Site Development Plan_V1.pdf Markup Summary

FOX RUN SUBSTATION		SITE PLAN	
TRI-STATE GENERATION & TRANSMISSION ASSOCIATION, INCORPORATED		4/12/2022 5:24 AM	
1100 W. 116th Ave. P.O. Box 33695 Denver, Colorado 80233 303-452-6111		KENDU	
Generation and Transmission Association, Inc.		Civl Dwg/Site Plan.dwg	
A Touchstone Energy Cooperative		No.	
Date: 12/16/21		Date:	
Appd:		Appd:	
Dwn: TMC		Dwn:	
Revision		Revision	
M.F.		M.F.	
Dwg. No.		M.F.R.	
Drawing Title		Reference Drawings

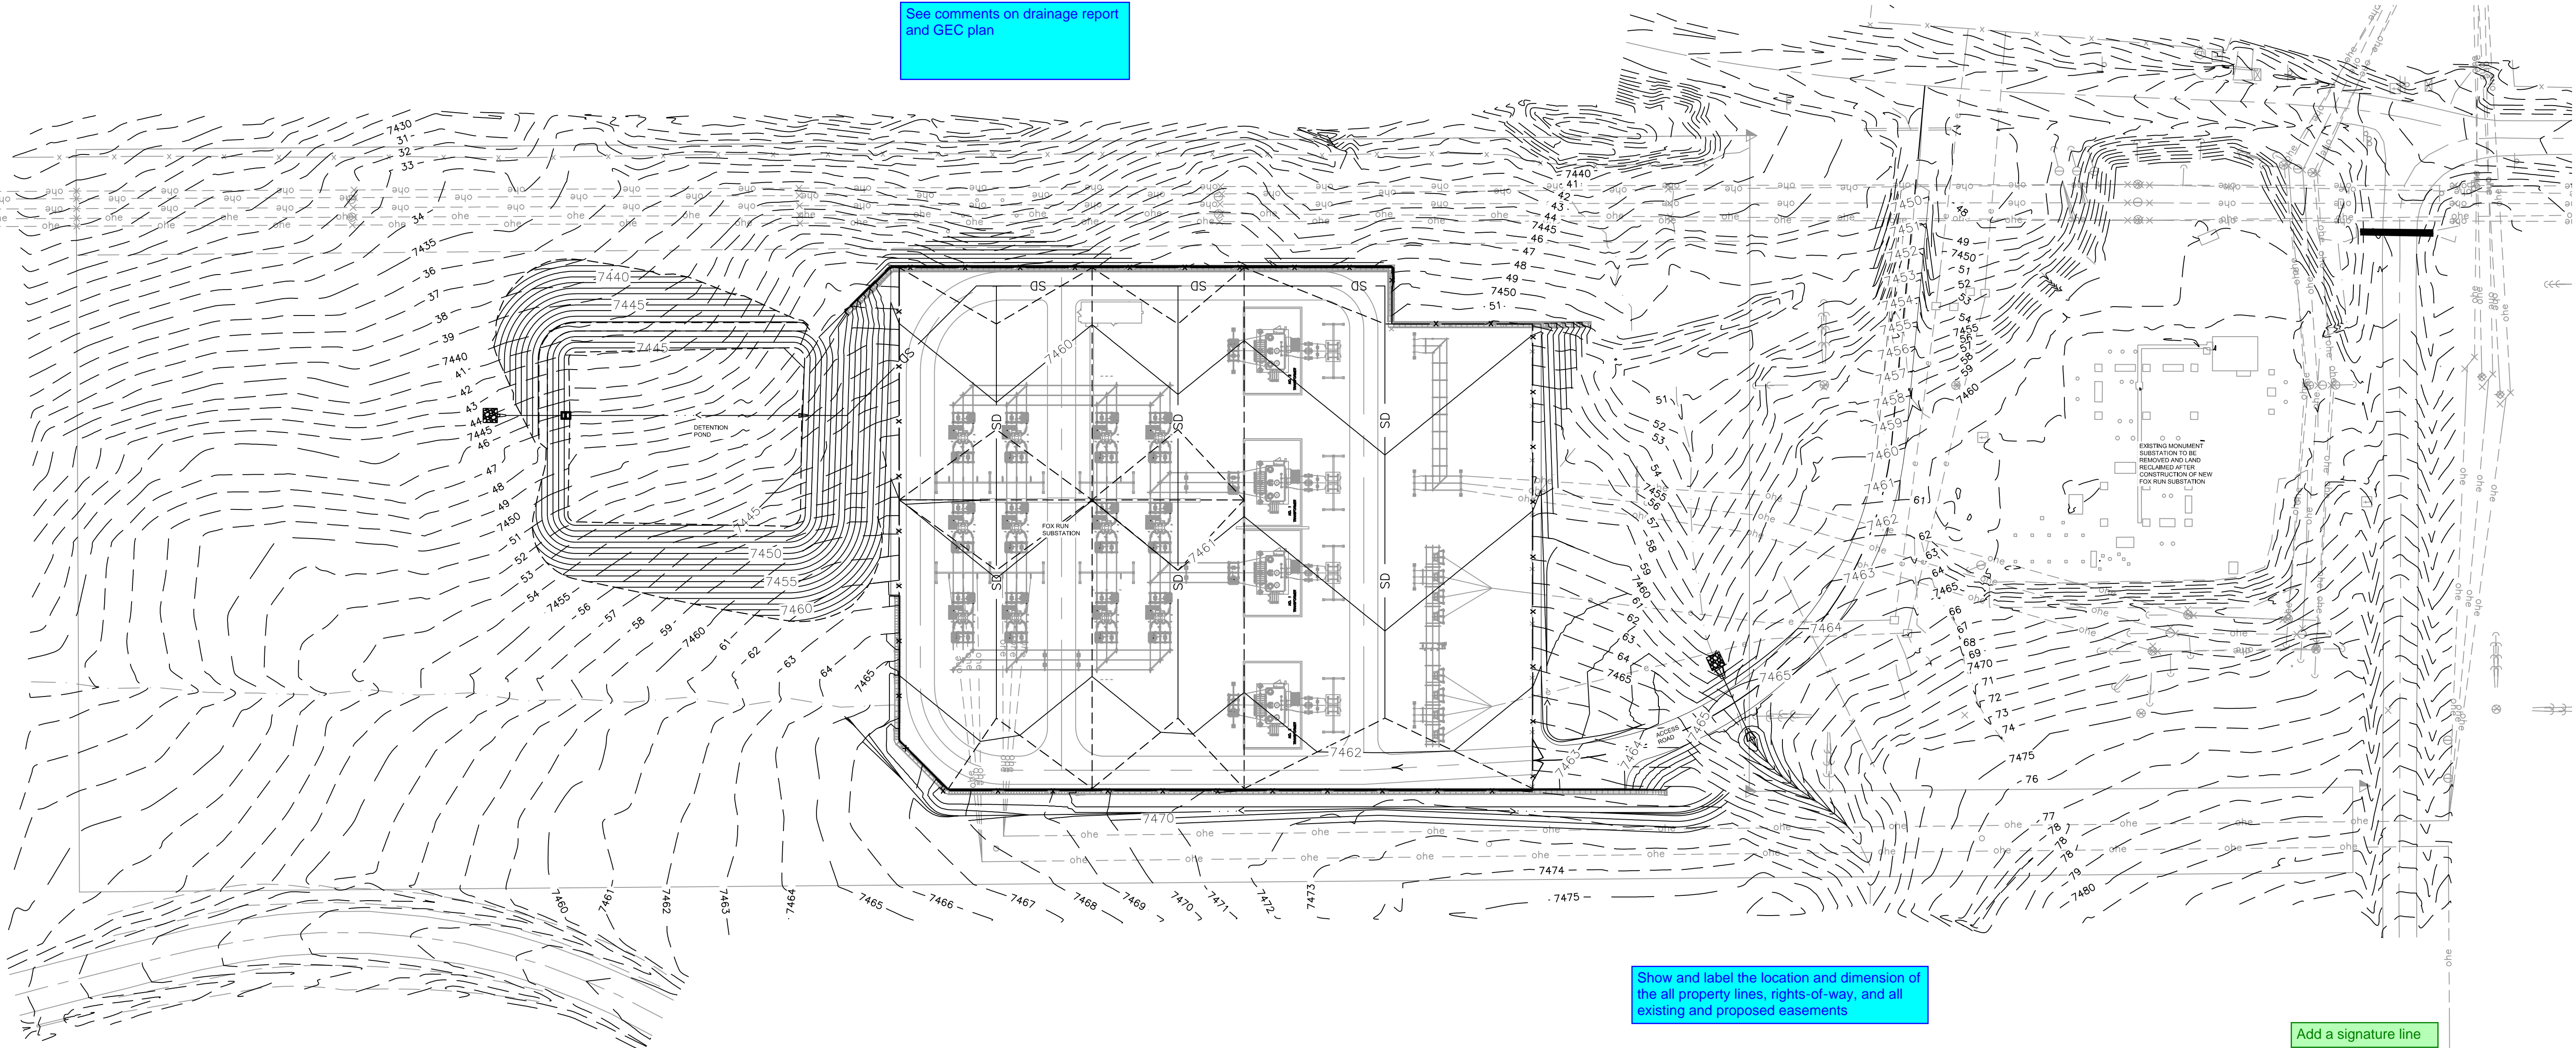
Add PCD File PPR-22-044

Show and label the location and dimension of the all property lines, rights-of-way, and all existing and proposed easements

Add property line (hvy) to legend and drawing

See comments on drainage report and GEC plan

Provide correct address. 1980 E Higby Road
Parcel # 6121003005

Add a signature line

- Include a summary table with:
 - Owner contact telephone number, and email for responsible party
 - Applicant name (if not owner), contact telephone number, and email for responsible party
 - Property address and property tax schedule number
 - Lot & Parcel size
 - Existing/proposed land use and zoning
 - Total gross building square footage - if any buildings are proposed
 - Location of all sidewalks, trails, fences and walls, retaining walls, or berms
 - Location and dimensions of all existing and proposed signage on site
 - Location and dimension of the all property lines, rights-of-way, and all existing and proposed easements

ELEVATIONS

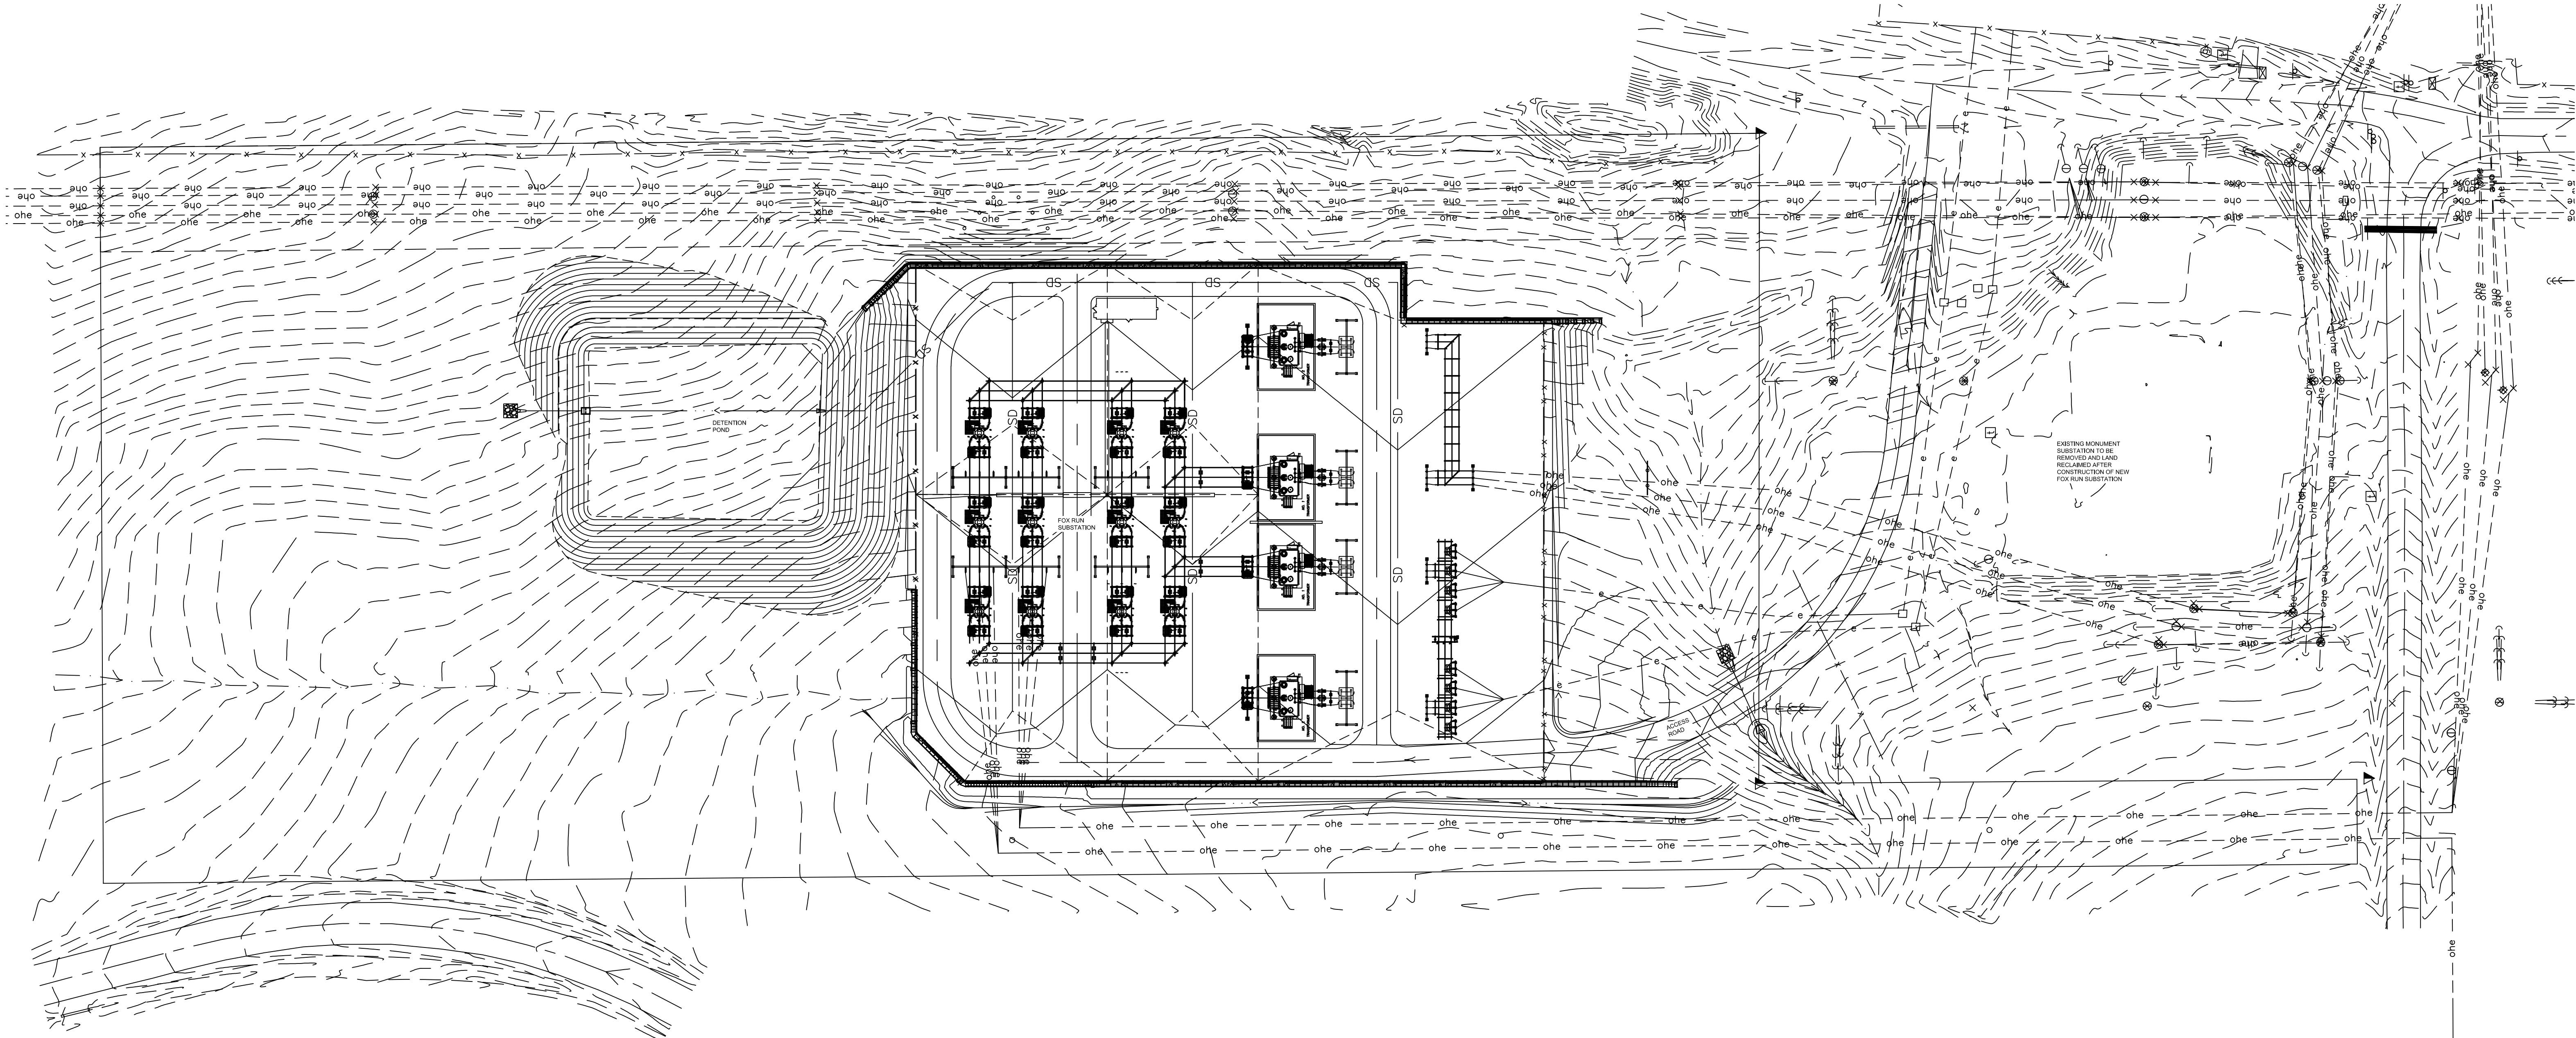
Lot is 652,806sqft

Add undisturbed native areas for total lot area to match project boundary
